Re: Evans Park PRD, 17909 25<sup>th</sup> Avenue NE (PA22-003)

Thank you for your project submittal. Upon first review of the above-referenced project, the Planning Division has the following comments/requirements.

[1 Evans Prak PRD, first technical review comments \(PA22-003\)](#)

A PORTION OF THE NW 1/4 OF THE SW 1/4 OF SEC 20, TWN 31 N, RGE 5 E, W.M., SNOHOMISH COUNTY, WASHINGTON

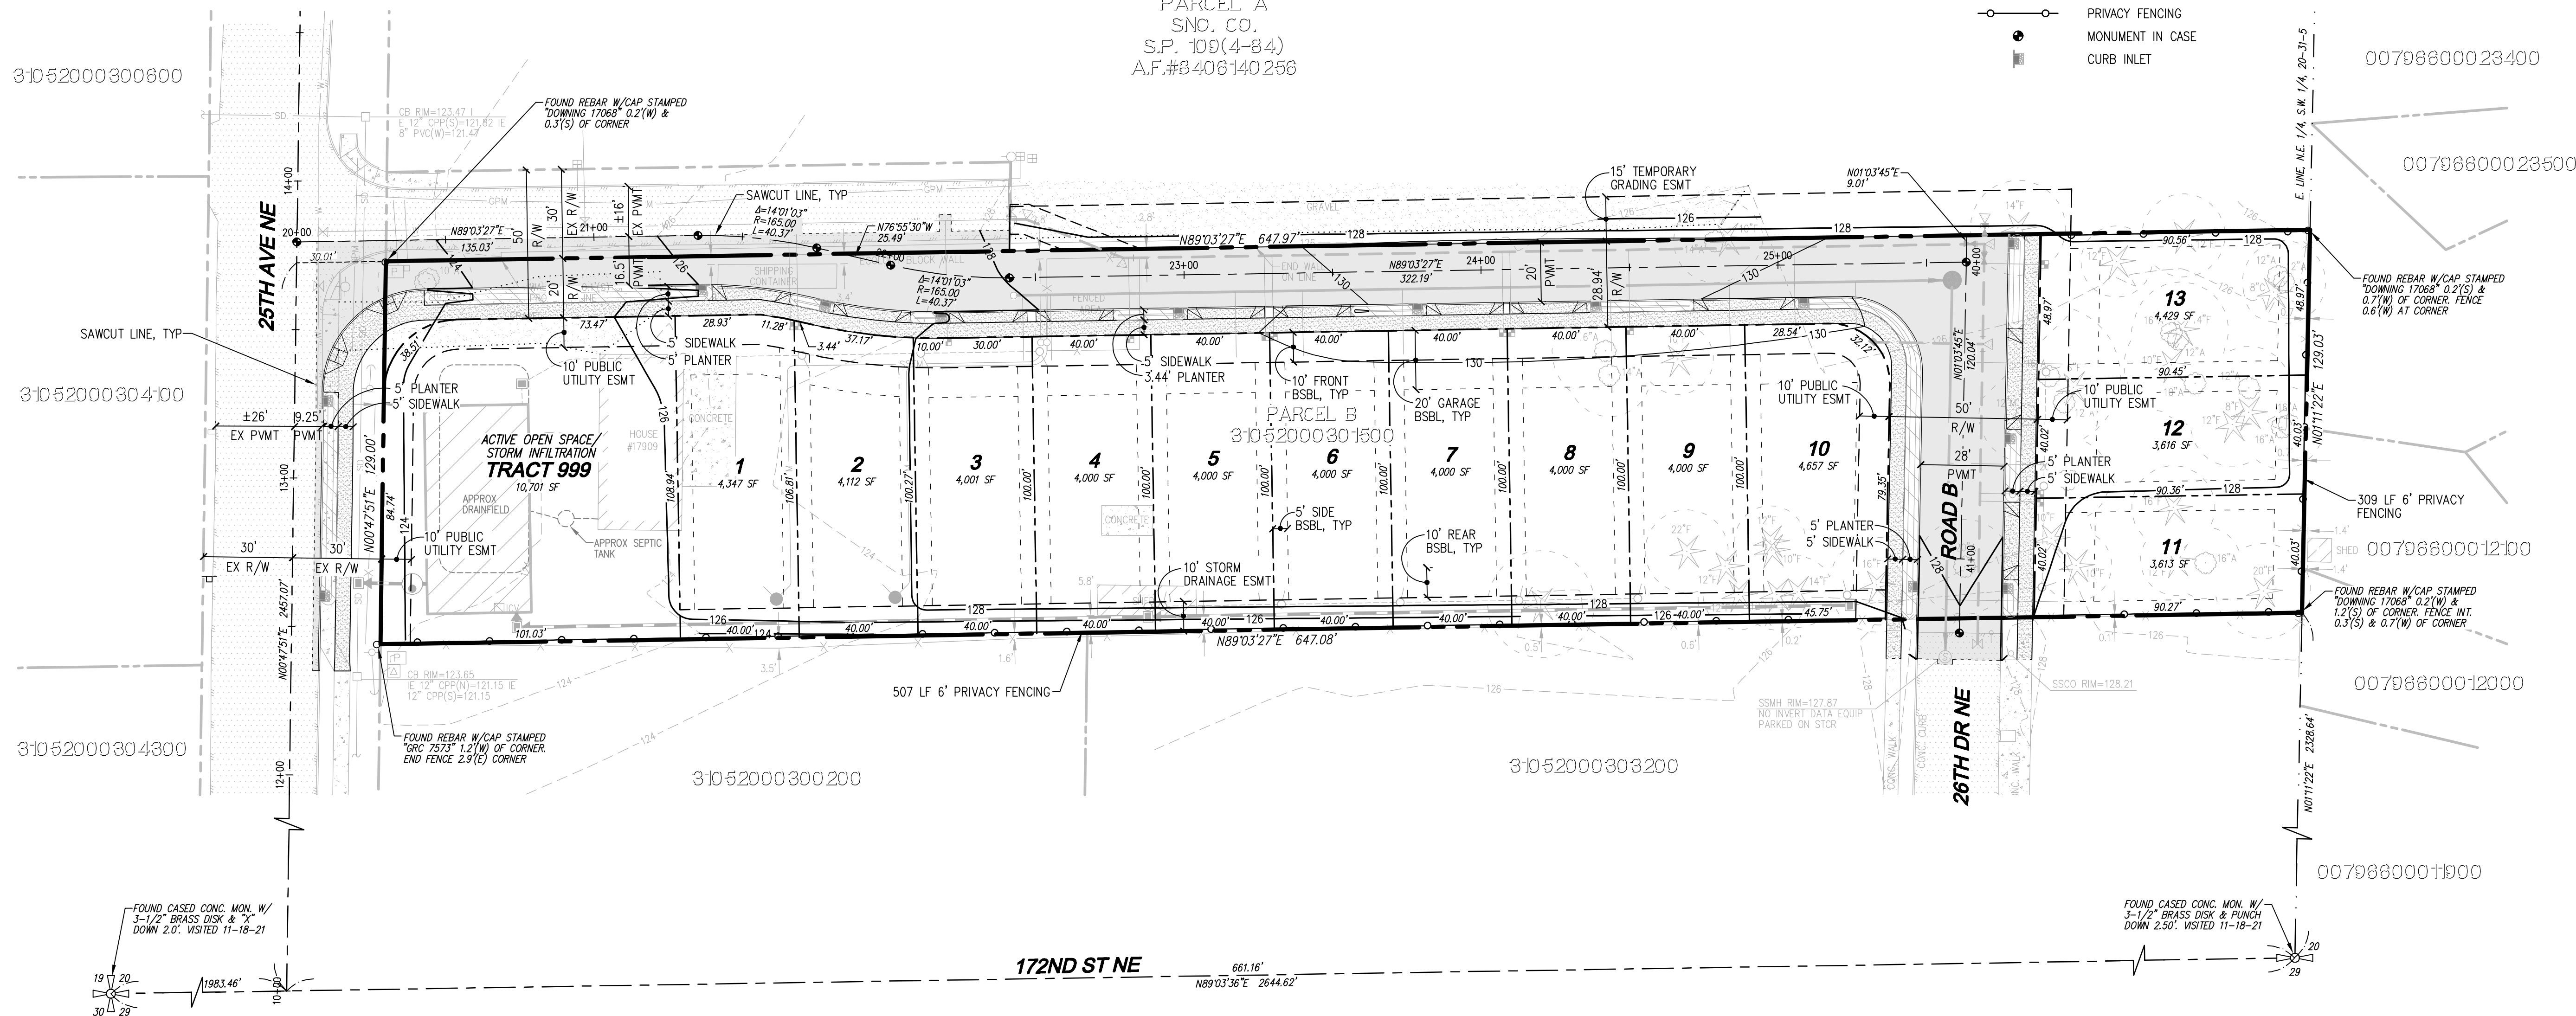
1. Please depict all easements on the plat map (AFN's 9909150395, and 202002120373).
2. Please add file number PA22-003 to map.
3. Please see comments from Jesse Hannahs regarding ROW dedication, lighting, and required construction of frontage improvements.

**Evans Park PRD**  
 LANDSCAPE PLAN

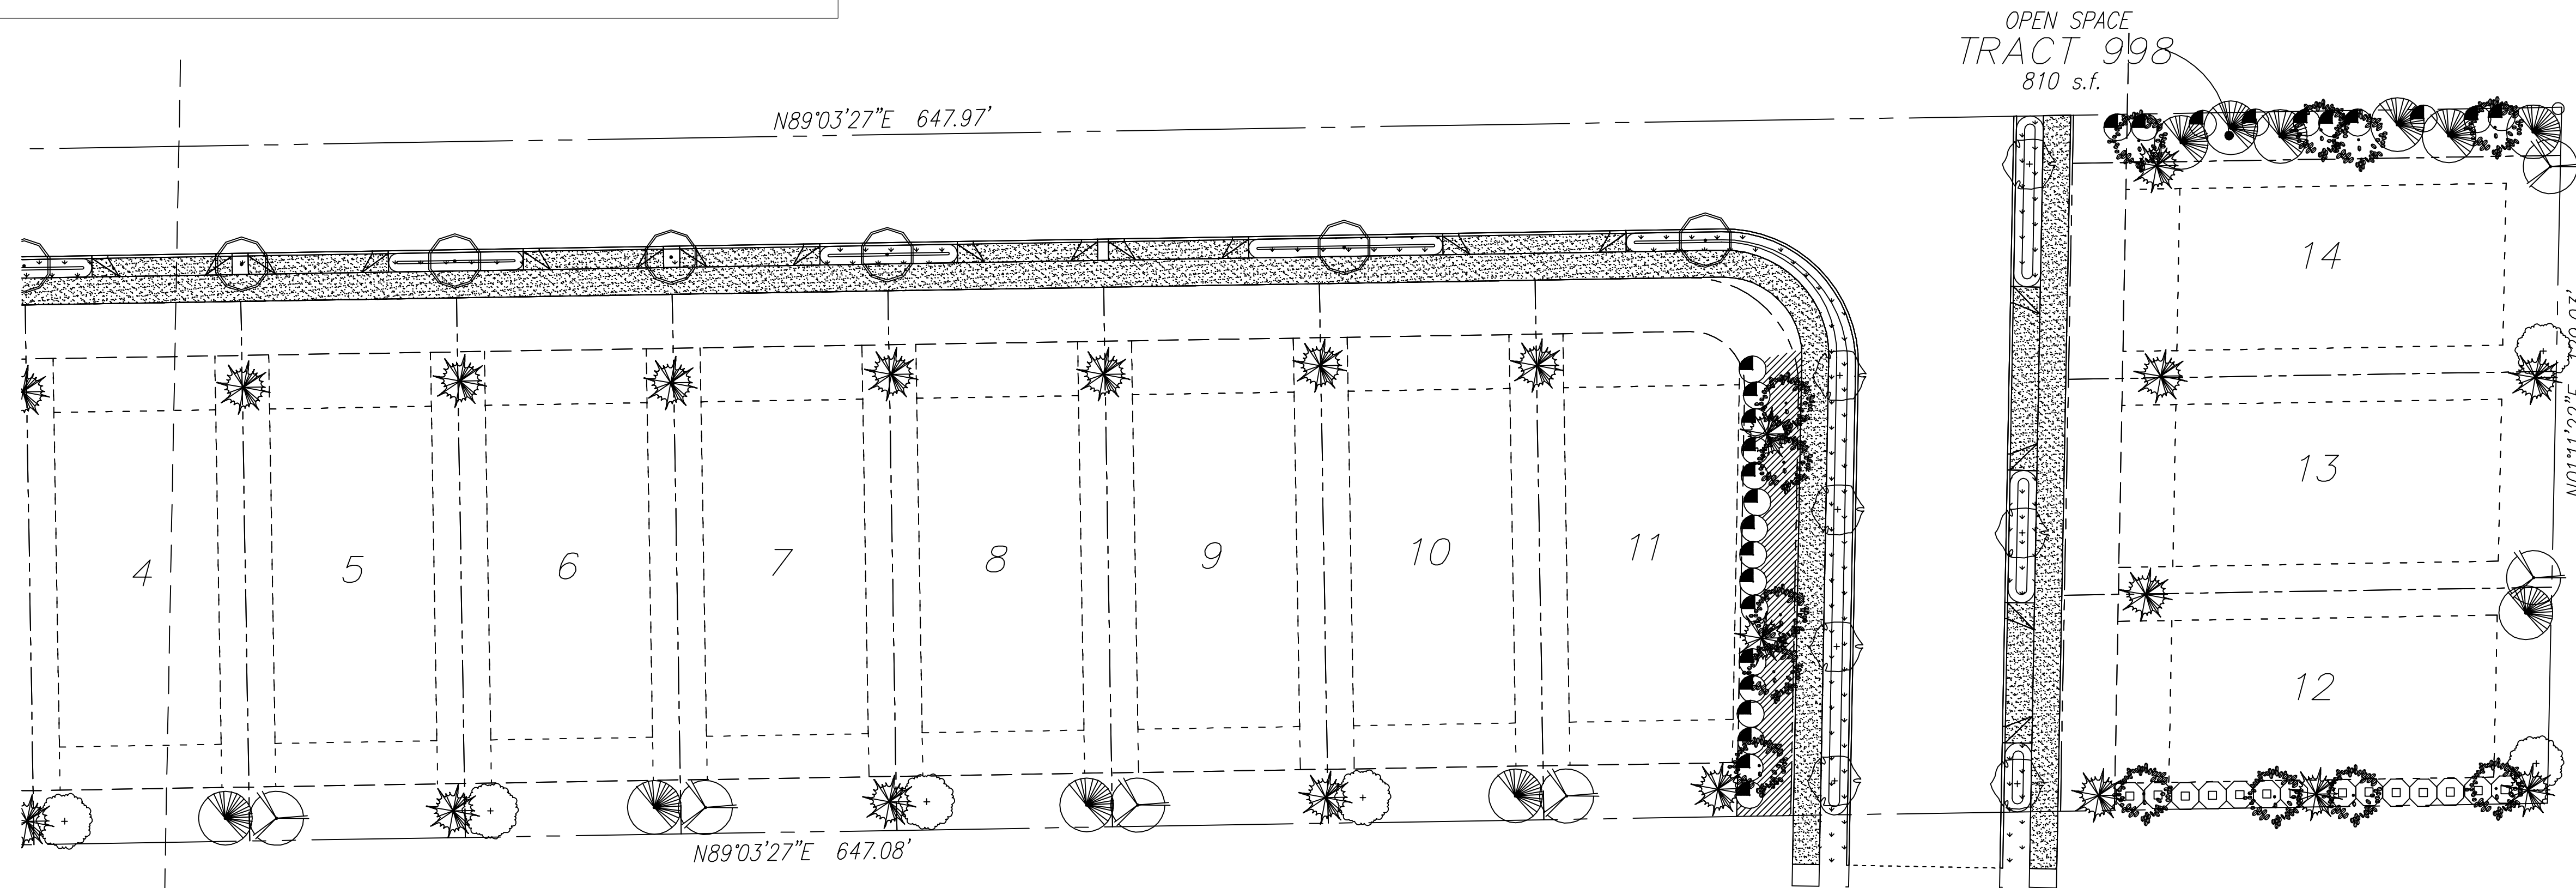
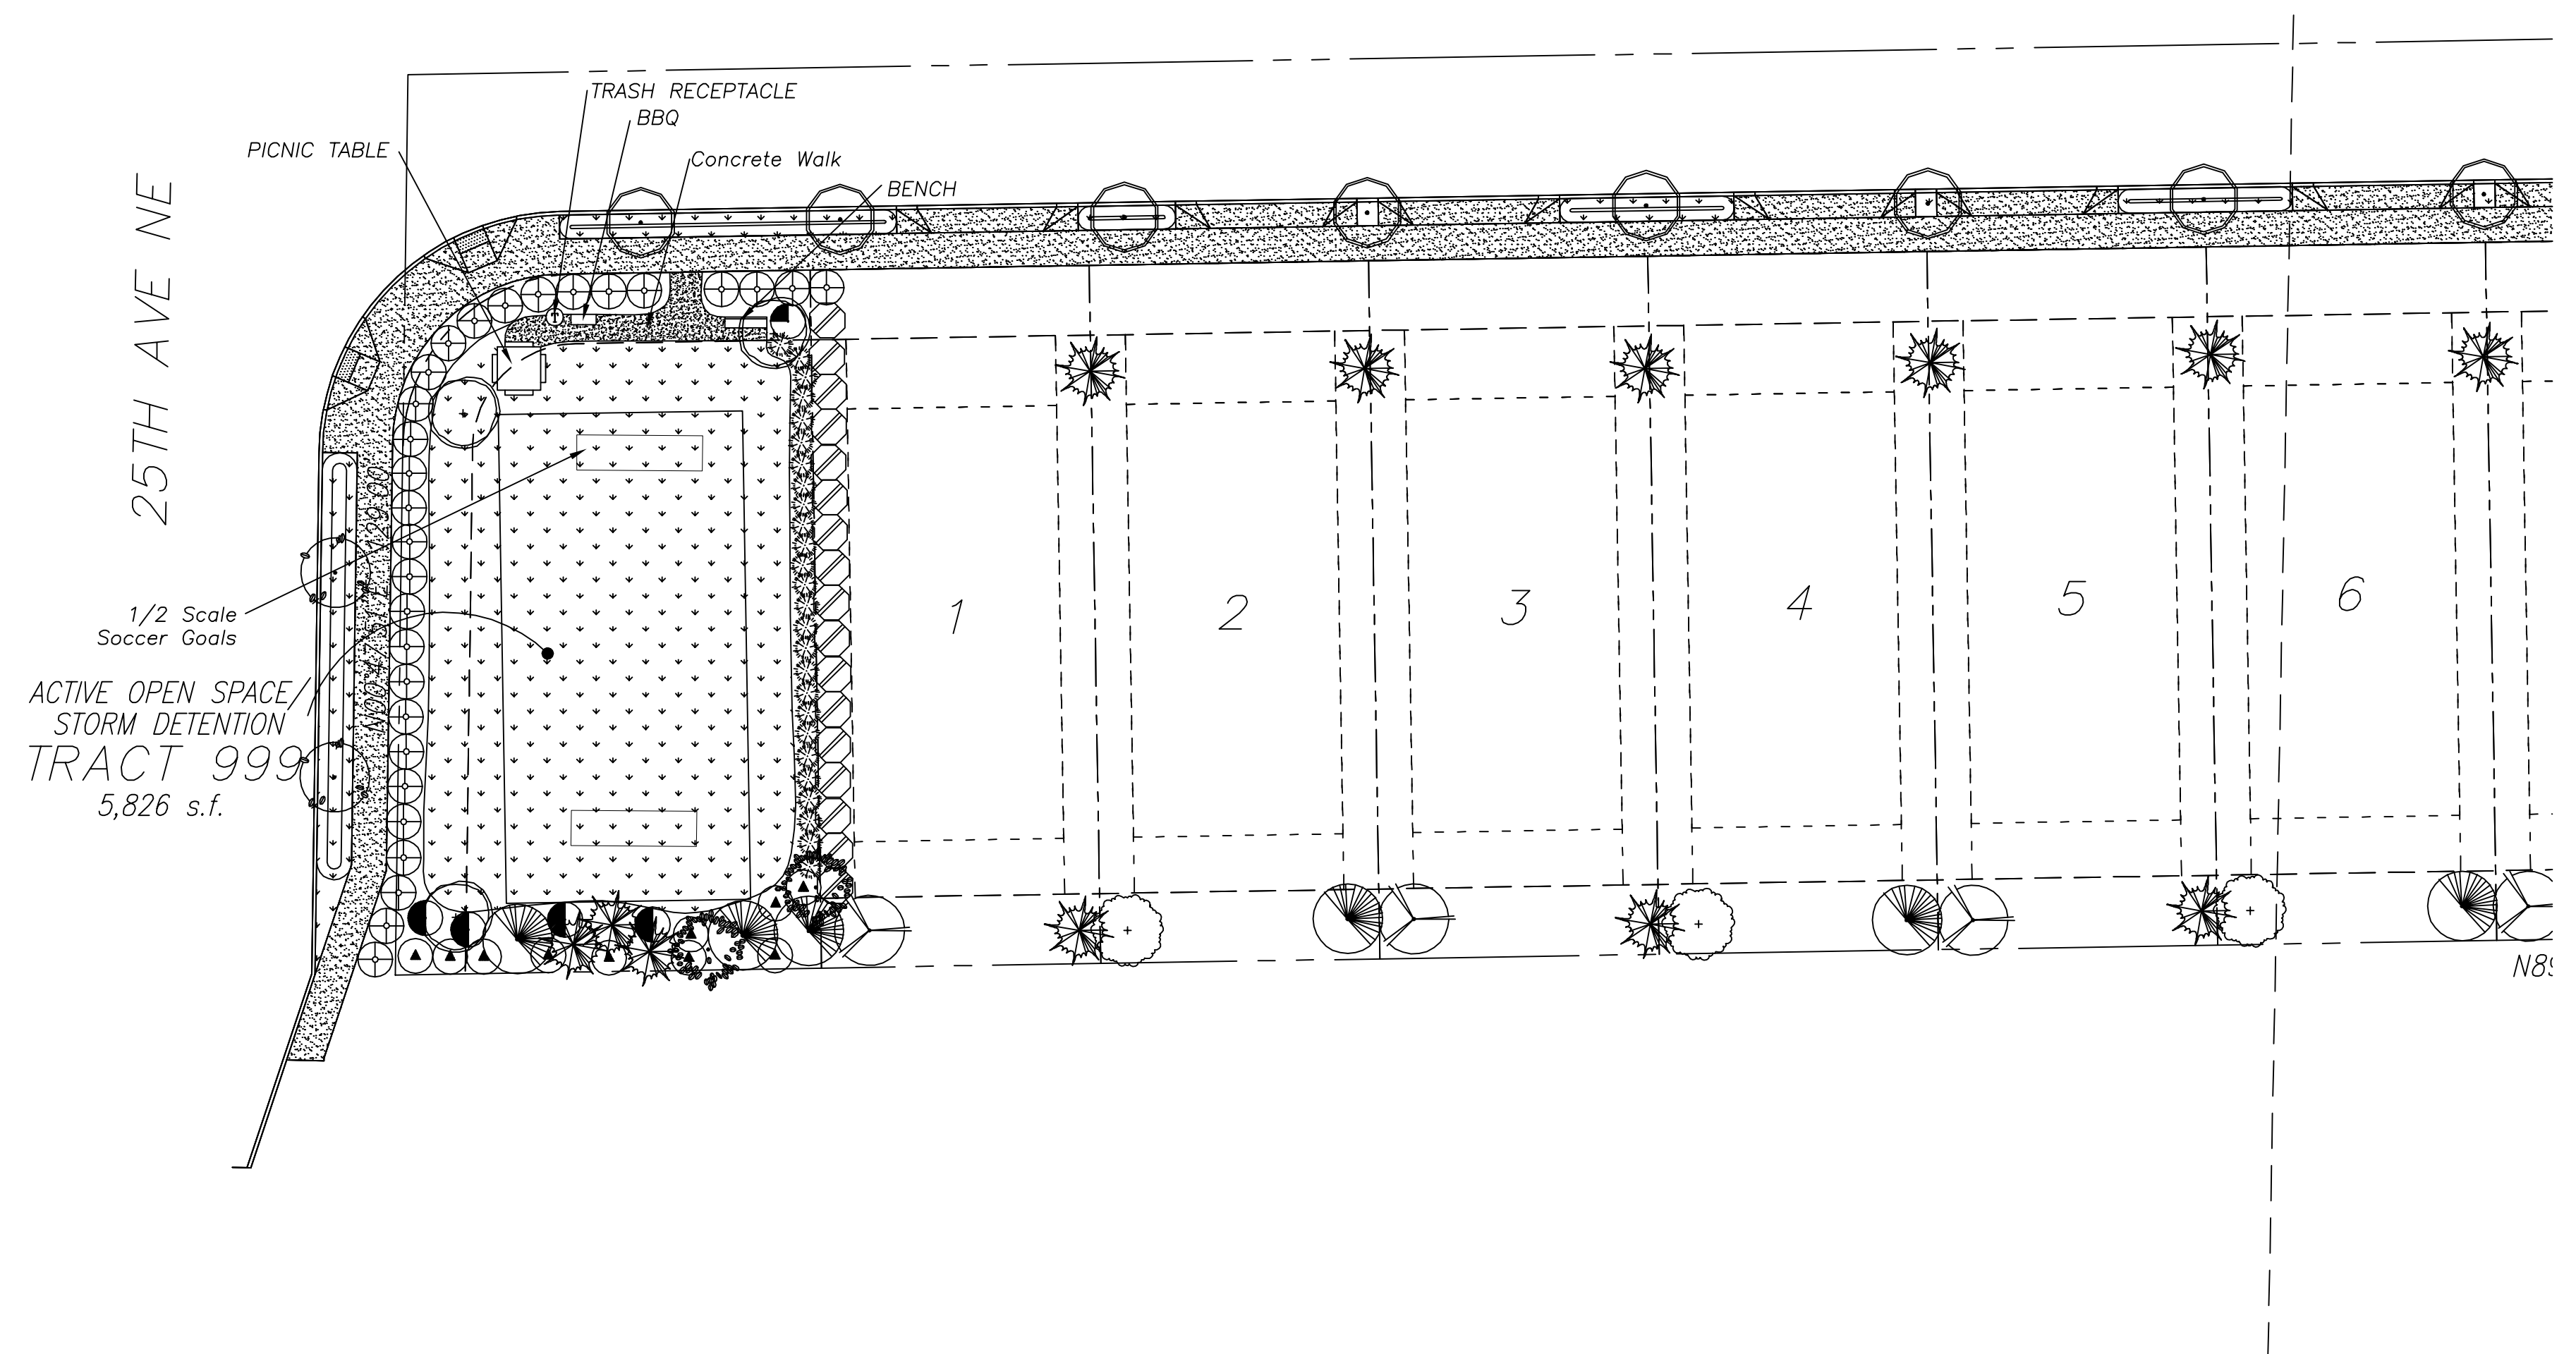
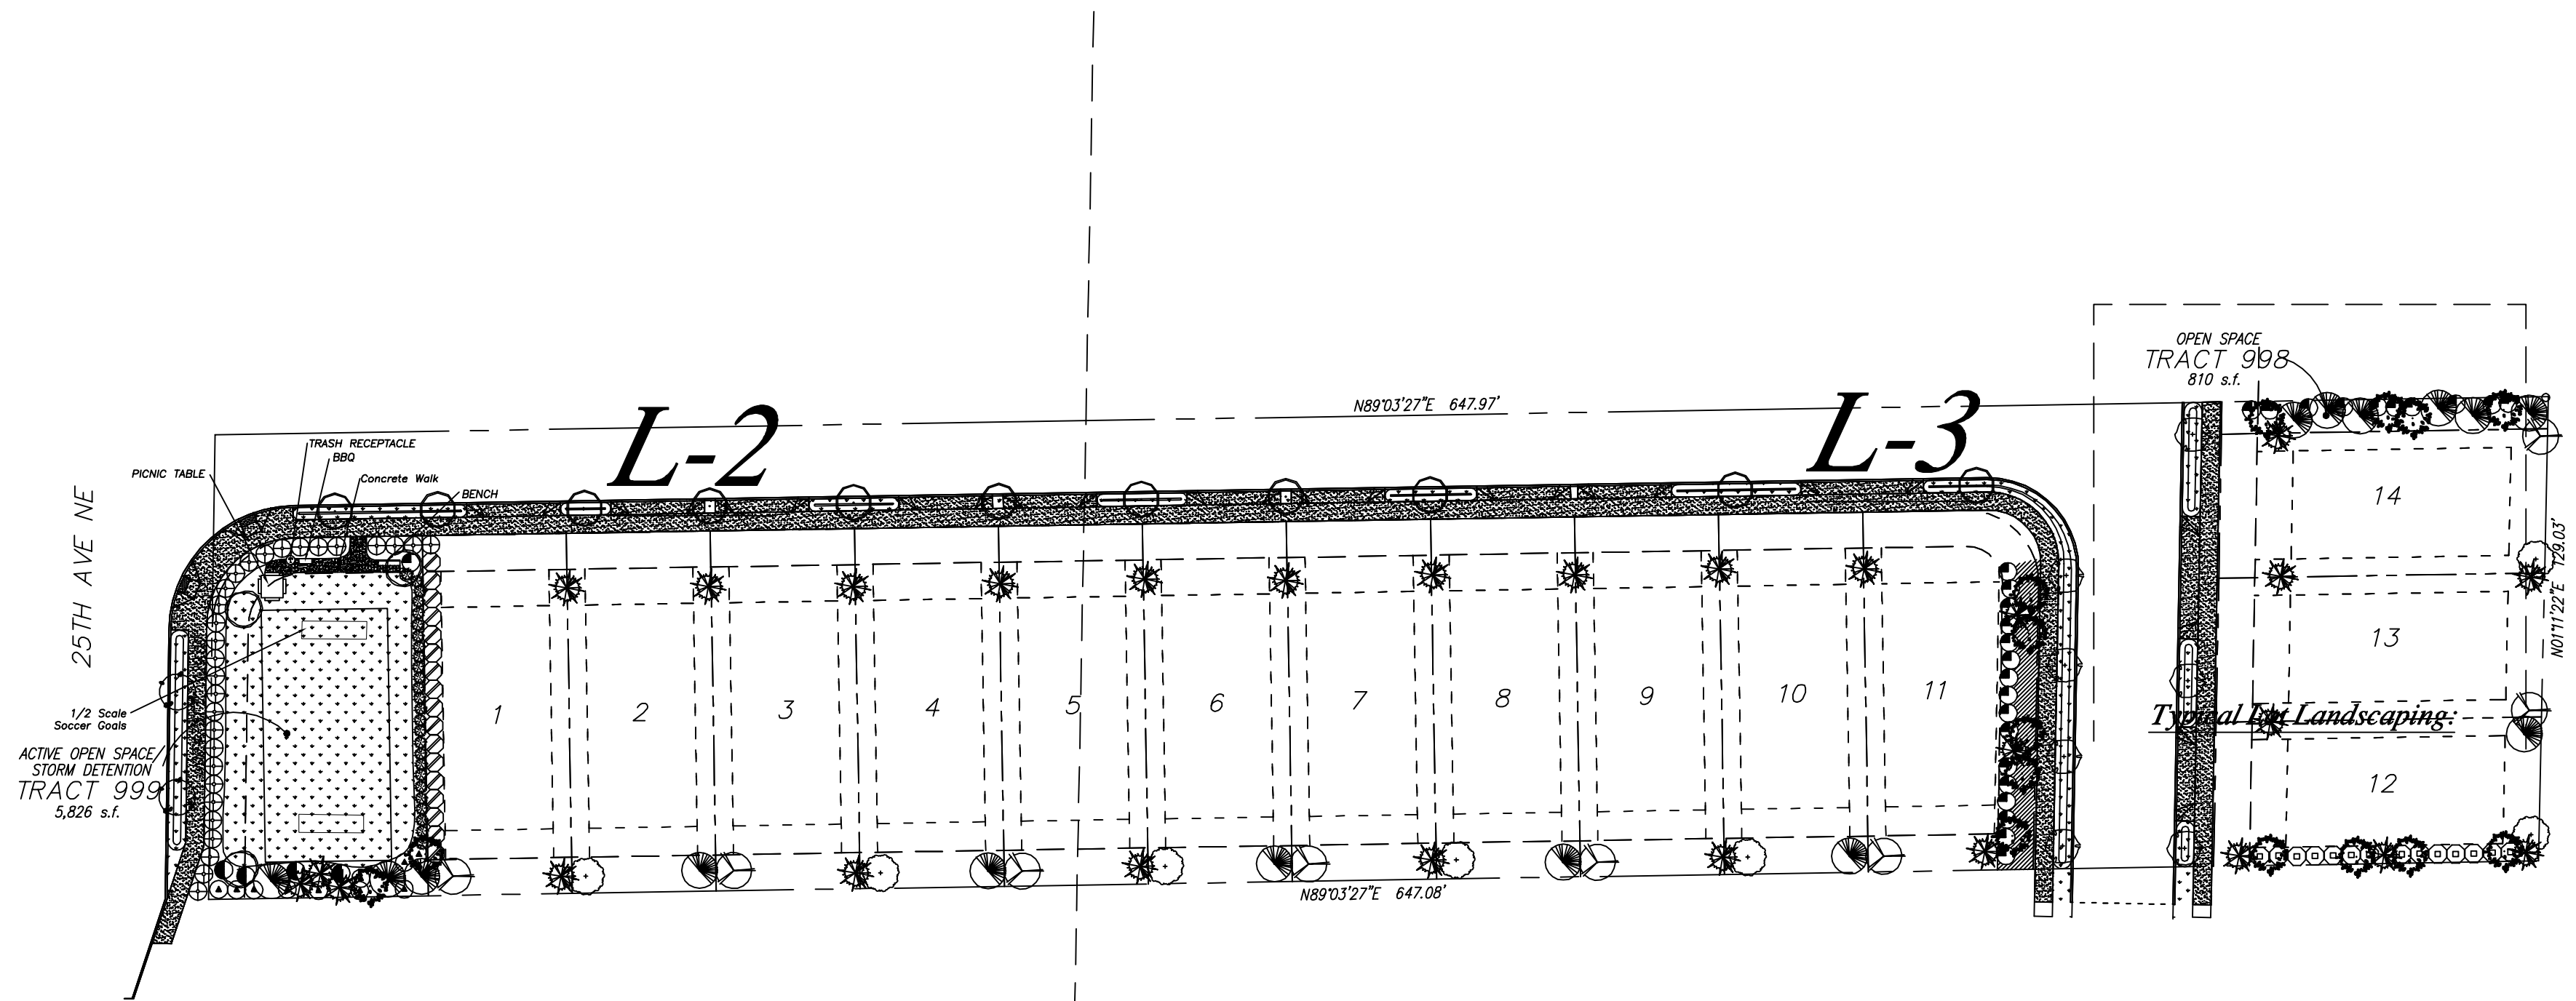
5. **The following comments are related to the landscape plan:**
  - The landscape plan shows a different number of lots than the plat map and preliminary civil plans. Please review and revise accordingly.

- Street tress on Road B shall be the same species as what is planted on 26<sup>th</sup> Drive to the south (proposed landscape plan appears to be in compliance).

- Pursuant to MMC Section 22G.080.100, "Fencing and/or landscaping shall separate, while maintaining visual observability of, recreation areas from public streets, parking areas and driveways." Fencing in compliance with the LNMP standards, or appropriate buffering, shall be installed along the western portion of Tract 999 to ensure that play equipment/users cannot accidentally enter 25<sup>th</sup> Avenue NE.

- Please provide details on any trails/paths, surfacing, paving, etc. that is proposed in the open space areas. Trails must be a minimum of five feet wide, meet Americans with Disabilities Act (ADA) standards, and be improved with an appropriate all-weather surface (gravel does not qualify).
